APPLEGREEN PLC

DEADLINE 2 SUBMISSIONS

**M42 Junction 6
Development Consent Order Application**

APPENDIX 1 - RESPONSES TO EXAMINING AUTHORITY'S FIRST WRITTEN QUESTIONS

M6: Junction 25

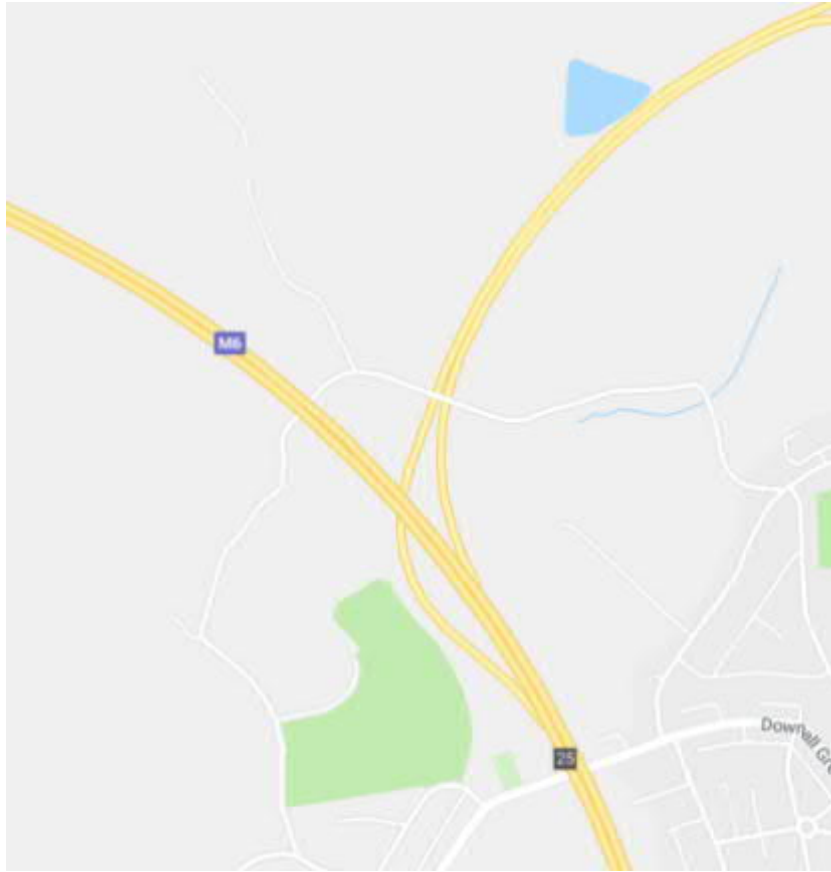
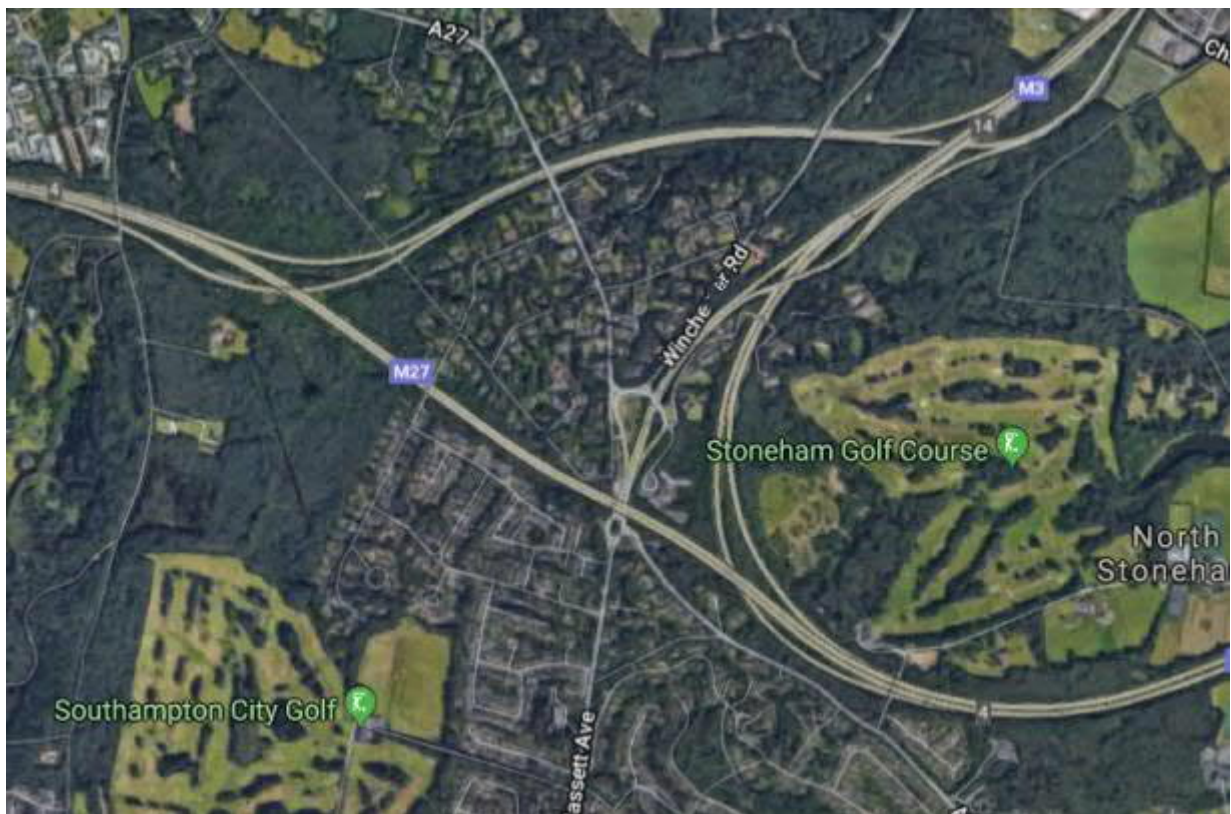
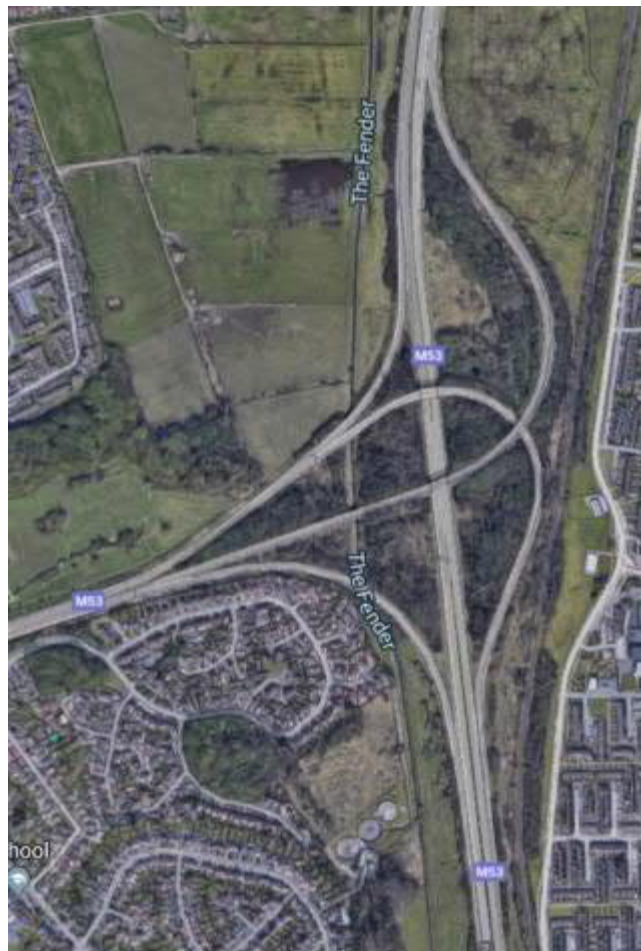
Cuthbert		<p>required to slow down at the point of give way despite there being very little if any circulating traffic. The presence of the roundabouts together with the need to give way is a less efficient arrangement as even without any conflicting traffic movements it will introduce an element of geometric delay.</p> <ul style="list-style-type: none"> • They avoid negative environmental consequences in terms of impacts upon noise and air quality associated with traffic slowing down and then accelerating away from the give way line. With a free flow arrangements traffic would be more likely to maintain a constant speed when leaving or joining the motorway. • They avoid the junction being used to facilitate ‘U’ turns on the motorway, with such movements adding an element of delay for other vehicles using the junction. • The junction motorway overbridge need only cater for traffic travelling in a single direction and therefore can be less wide. • Roundabouts, with their requisite land take and lighting requirements etc. are not required. <p>The junction design provided by Mr Cuthbert, whilst demonstrably preferable to the proposed dumb-bell arrangement, could be further optimised in that the northbound off slip road radii could be tightened to decrease the impact on the Ancient Woodland at Aspbury’s Copse. It could be materially further improved by way of moving the free flow junction further to the north. This would:</p> <ul style="list-style-type: none"> • Avoid impacts on the Ancient Woodland altogether. • Avoid or reduce the substandard weaving length between J5 and the new J5a. <p>In order to evidence the foregoing, a review has been undertaken of all the “M” roads in England including the M6 Toll Road. Motorway standard “A” roads have not been included in this review. All junctions where a single road connects to a motorway have been identified and categorised on the basis of whether they have one or two way facing slip roads and whether they take the form of a free flow junction or an interchange. In this case free flow is defined as when traffic can move between the motorway and the side road without passing through a give way or stop line. The results of this review are set out in the table below and plans of the junctions are shown in Appendix E.</p>

The review identified 42 junctions on the motorway network which connect to a single road. Of these junctions 19 had slip roads facing in one direction and 23 had slip roads facing in both directions on the motorway. **All** of the junctions which had slip roads facing one way were free flow.

In conclusion, it is clear that the junction form proposed in the DCO has been selected to accommodate north facing slip roads. This arrangement has demonstrable disbenefits and evidence from a review of the motorway network shows that this type of interchange is only used to connect a motorway to a single road when slip roads are provided in both directions.
